SSD-32275057

Redfern Mixed Use Co-living Housing Objection

29th November 2022

175-177 Cleveland St and 1-5 & 6-8 Woodburn St, Redfern
DRAWING:
SOUTH ELEVATION

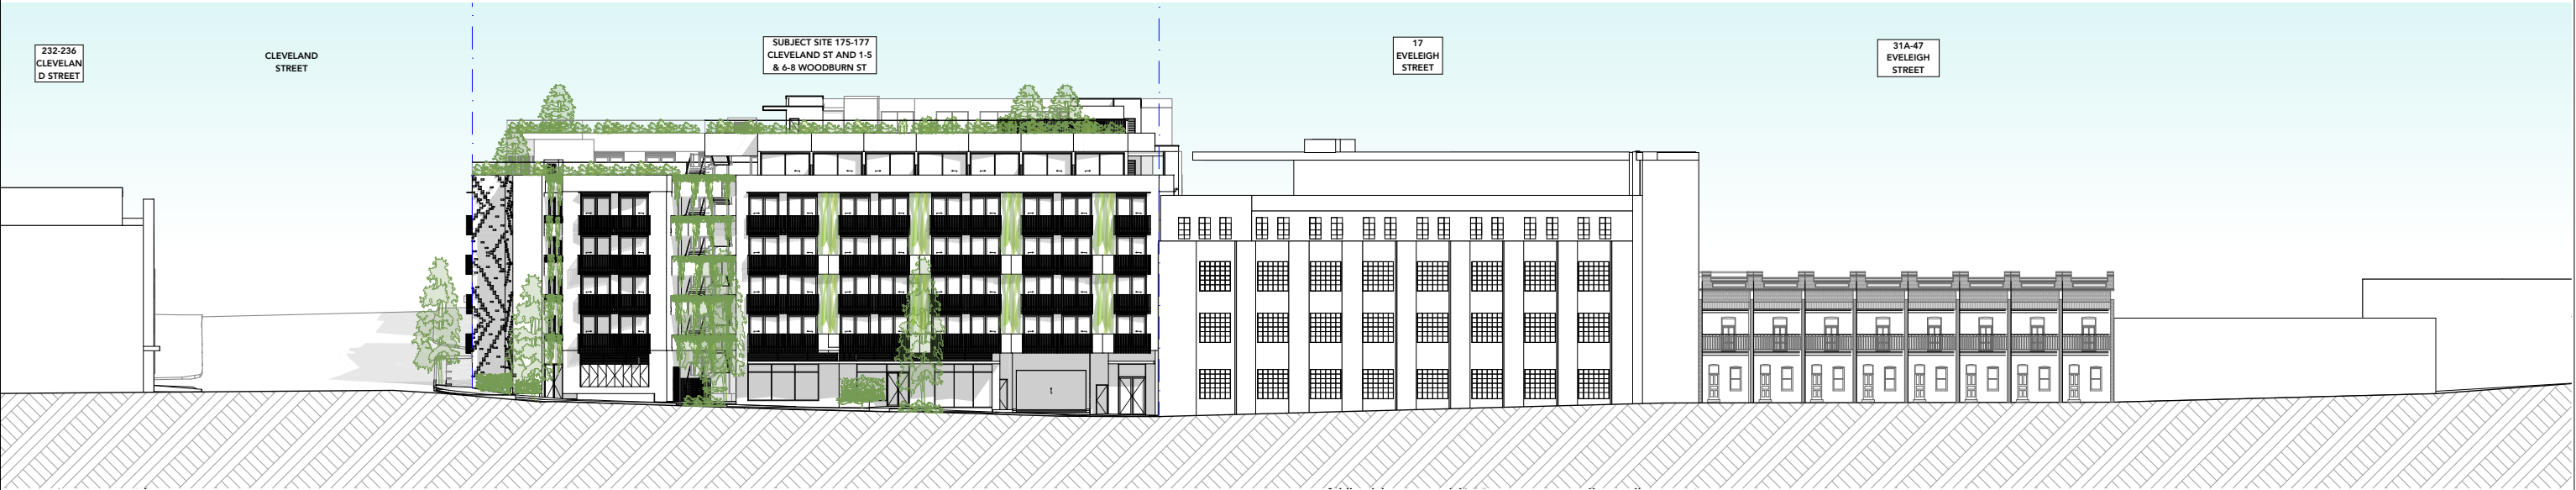
Response: This statement is incorrect, the proposal has completely ignored the scale, form and design of the three two storey terrace houses located directly to the south of the non-compliant bulk and scale of the seven storeys.

At 5 storeys, which is the maximum height approvable under the planning controls, the building form has an appropriate height, bulk and scale which will not result in a loss of amenity for neighbouring buildings. The additional 2 storeys are located so as to have maximum impact on the three 2 storey terrace houses located directly to the south of the proposed height contravention.

175-177 Cleveland St and 1-5 & 6-8 Woodburn St, Redfern
DRAWING:
WINTER SOLSTICE PLAN SHADOW DIAGRAMS 11AM-12PM

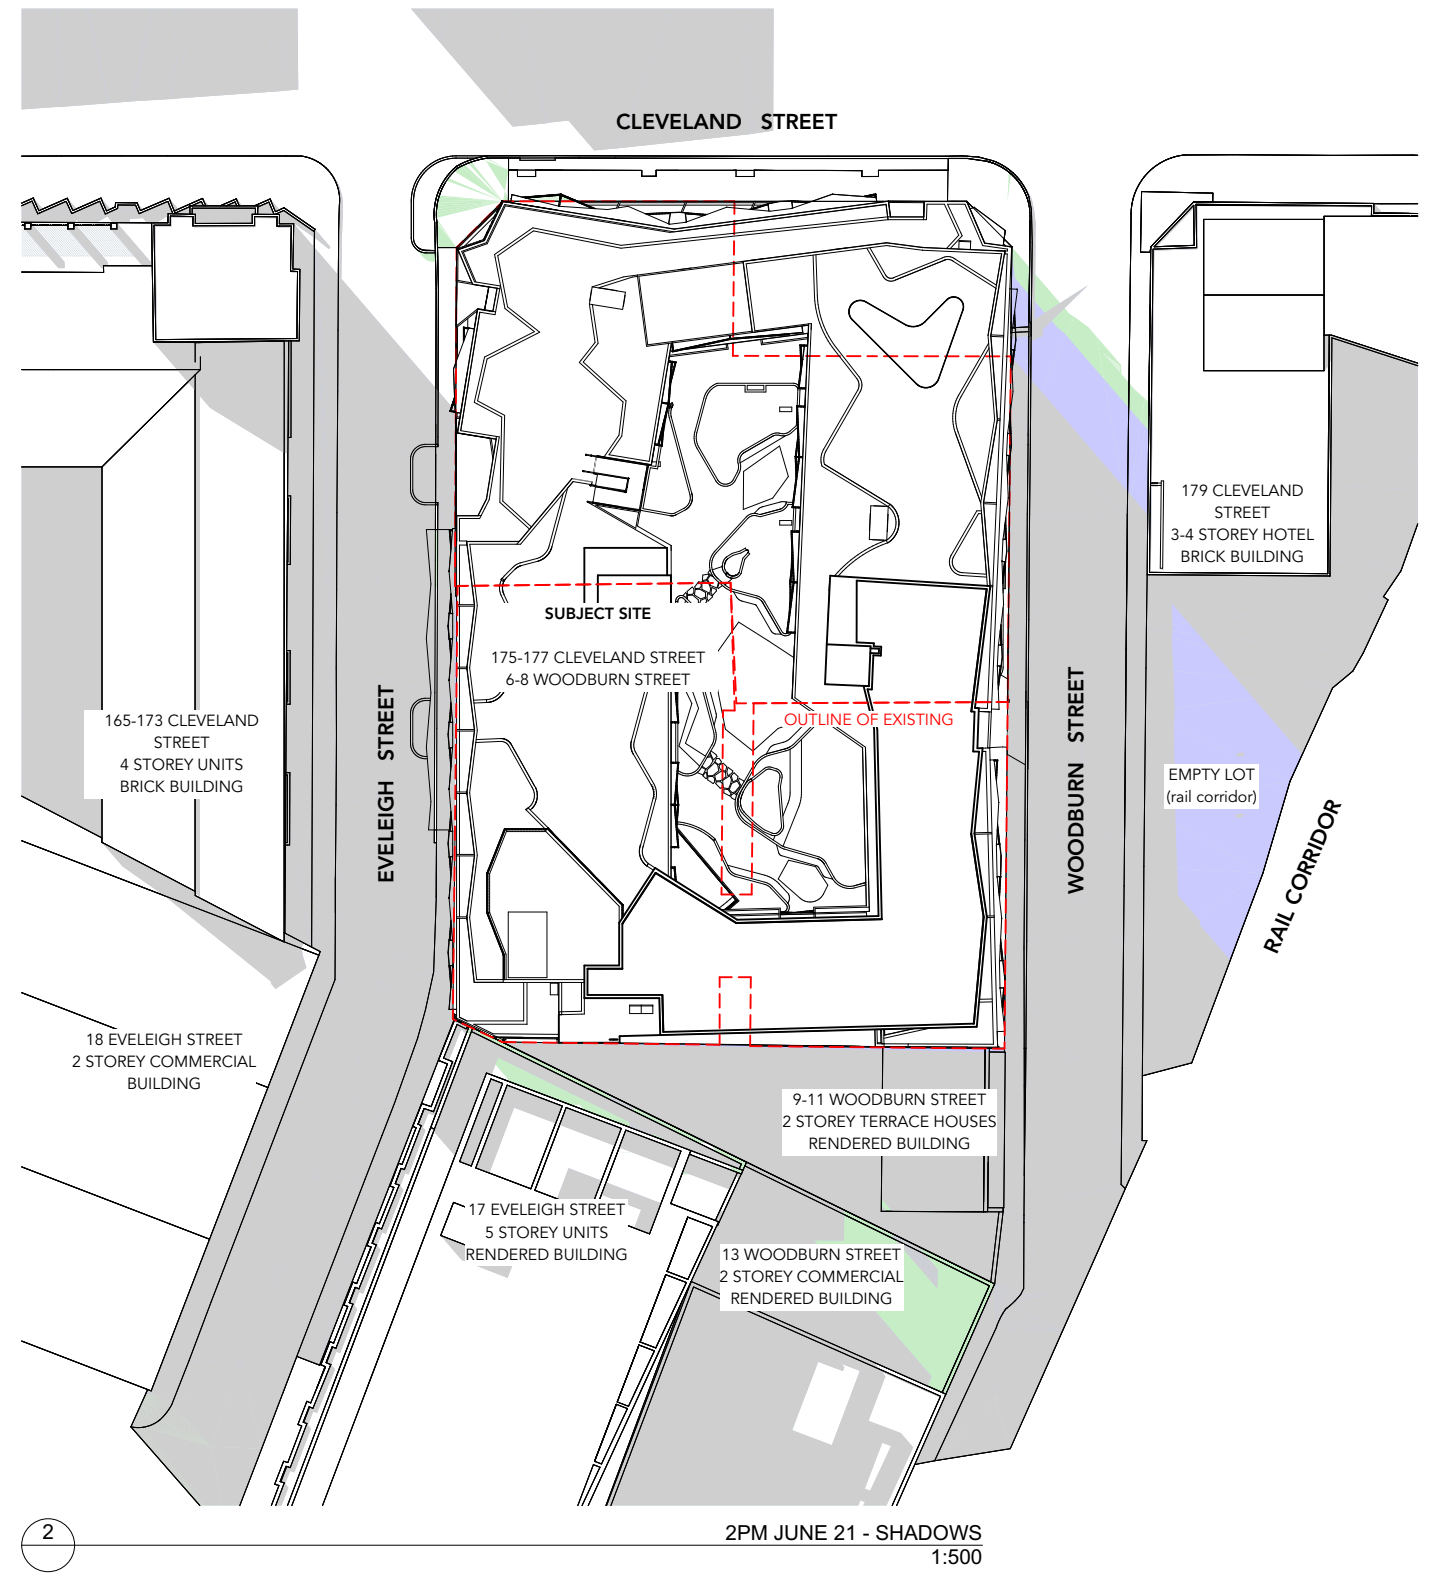
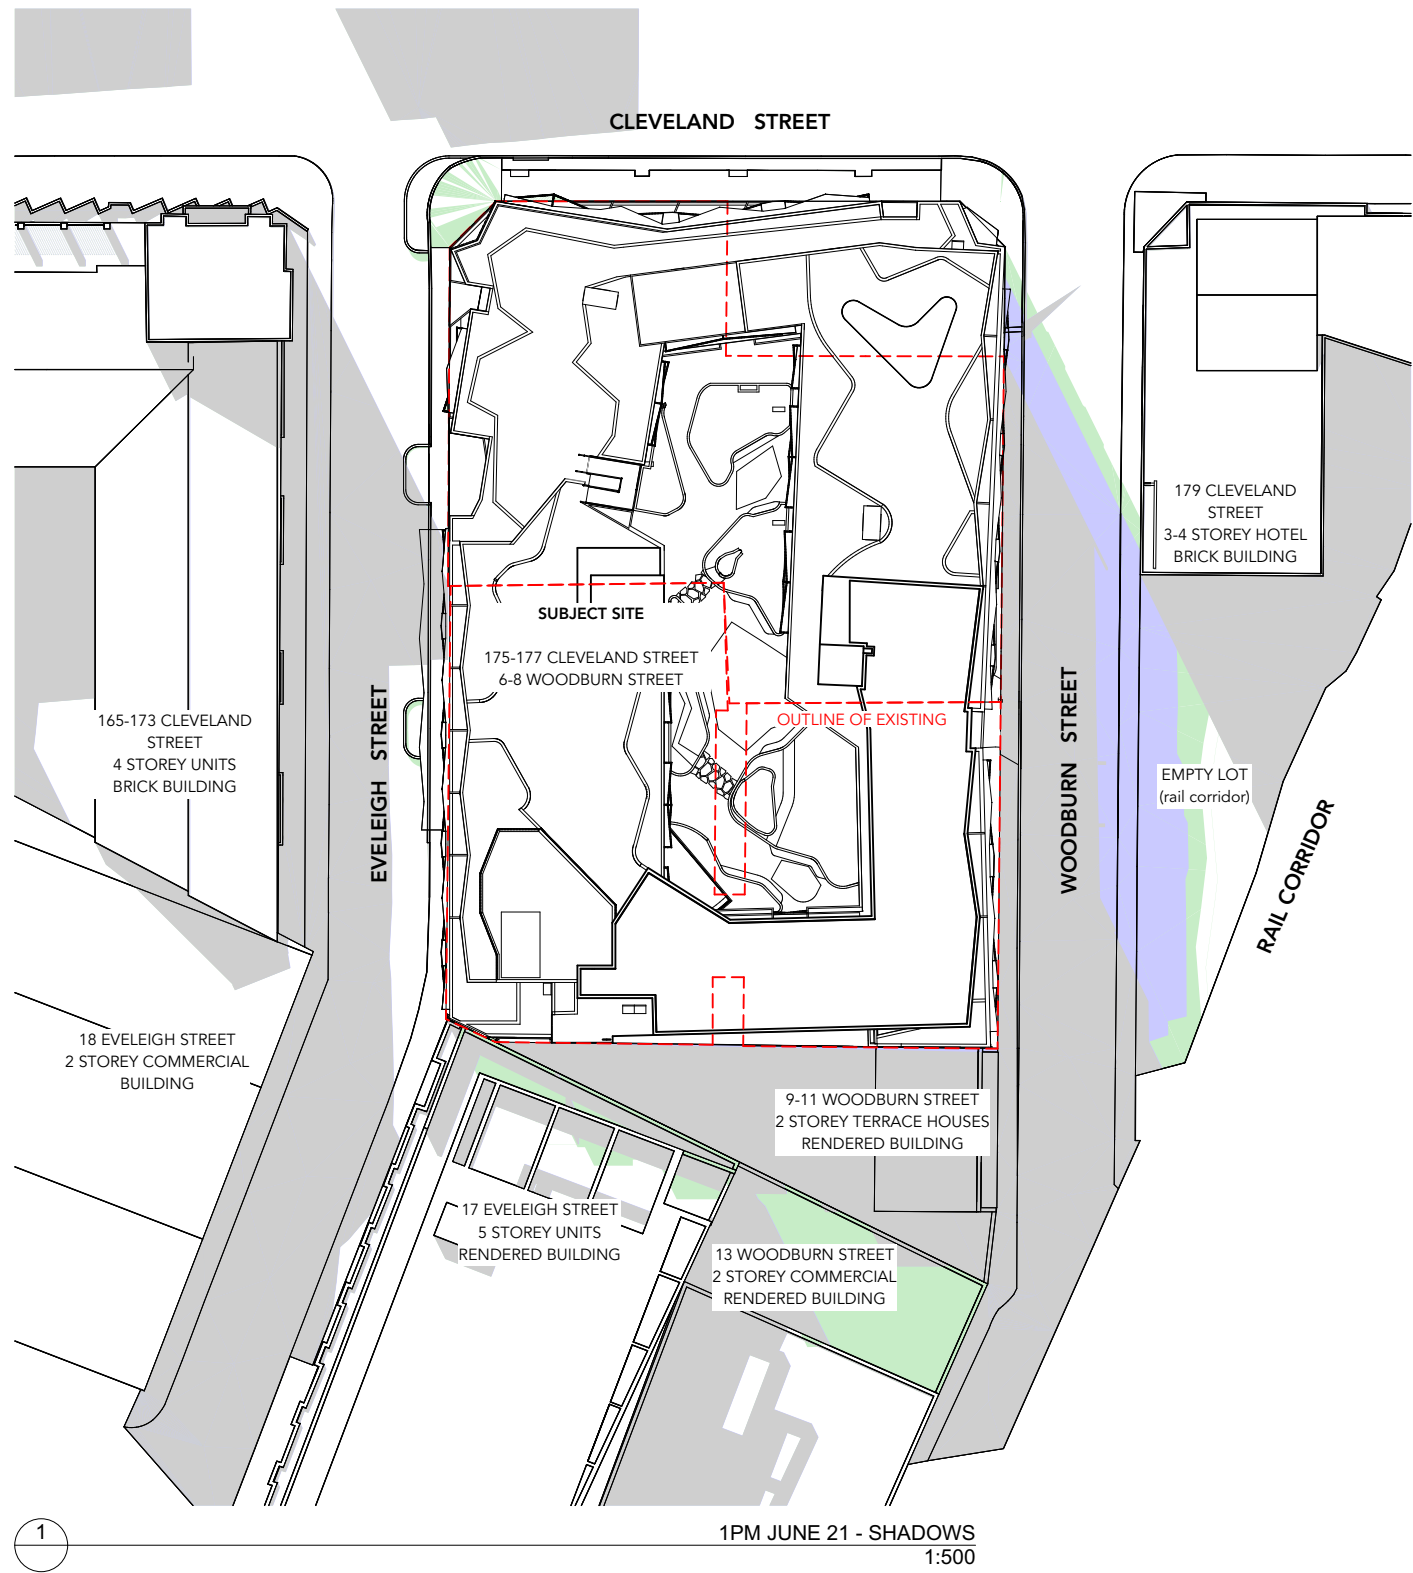
Response: It is easy for a person sitting in an office, who is not directly affected by the overshadowing to state that the overshadowing is *"acceptable"* or minor. The level to which No. 9, 10 and 11 Woodburn Street are already overshadowed means that any additional overshadowing has enormous impacts on our health and amenity. It is possible to design a successful, approvable scheme that complies with the 5 storey height control and does not produce any additional overshadowing to the two storey residential terraces located directly to the south at 9, 10 and 11 Woodburn Street.

Response: This is incorrect. The proposed seven storey bulk located directly north of 9, 10 and 11 Woodburn Street will increase overshadowing and decrease the amount of daylight received to the private open space. Any scheme that increases overshadowing and decreases amenity cannot claim to *"optimise solar access for the adjacent properites"*. This is not simply a matter of overshadowing, the height, particularly to the north of our properties, of the development also removes skyview and further encloses the rear private open spaces of the terraces. It may be difficult for the developer to engage with the interface between the small terraces and their desire for an overscaled building, but the contextual and amenity controls require that design consideration, and a resolution that at least does not make the interface worse than it presently is.
